Rosefield Solar Farm (EN010158)

**Buckinghamshire Council's comments on the Applicant's
Response to Deadline 2 Submissions**

Buckinghamshire Council

June 2026

Plate 7.1: Proposed PRow diversions and permissive paths in Parcel 1

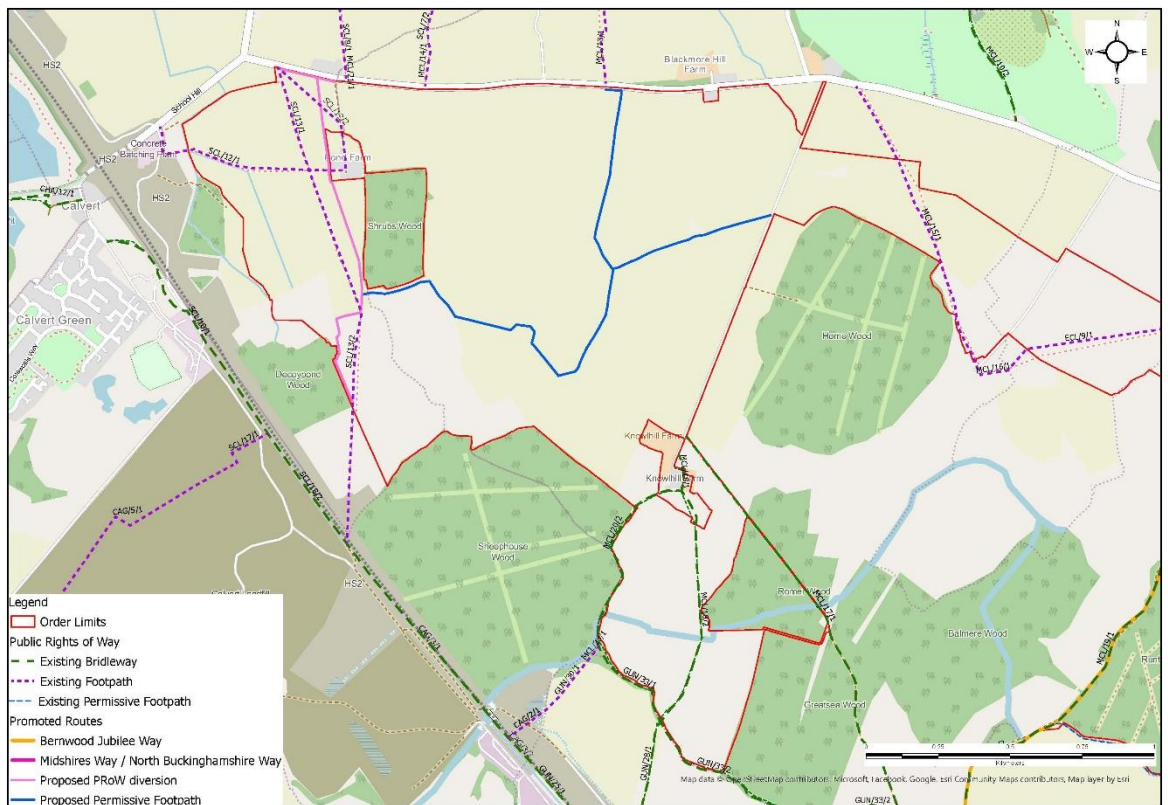
6.1.12	14, row 3	Comment disagrees with the Applicant in that the revised footpath diversion for the deleted and created network north west of Pond Farm in Parcel 1 is not considered the best layout possible. Further comment noting that the alignments do not reflect the desire lines proposed by Buckinghamshire Council in November 2025. Comment noting difficulty in interpreting the pink and turquoise lines on sheet 1 of the Streets, Rights of Way and Access Plans.	The Applicant considers that there is benefit in the proposed arrangement for those undertaking circular walks from Steeple Claydon, providing a link between footpath MCL/21/1 north of Calvert Road and the new footway created by HS2 along Addison Road. It has been agreed with Buckinghamshire Council to update the Design Commitments [EN010158/APP/5.9.5], to include a design commitment that the diverted PRoW in Field B5 (SCL/12/2 and SCL/13/1) will not be fenced during operation (including maintenance), to address their concerns on this matter. In relation to the interpretation of the pink and turquoise lines on sheet 1 of the Streets, Rights of Way and Access Plans [EN010158/APP/2.4.3] [REP1-006], the pink lines indicate where works may occur along roads and/or PRoW during the construction phase and would not be included on the definitive map. The turquoise lines are those anticipated to be included on the definitive map. Paragraph 8 in Section 3 of the Draft DCO [EN010158/APP/3.1.5] explains what 'Street Works' cover and Schedule 4 of the Draft DCO [EN010158/APP/3.1.5] provides a list of the 'streets' anticipated to be subject to 'Street Works', along with a description of the anticipated extent of works.	The Council considers both of these matters now to be resolved.
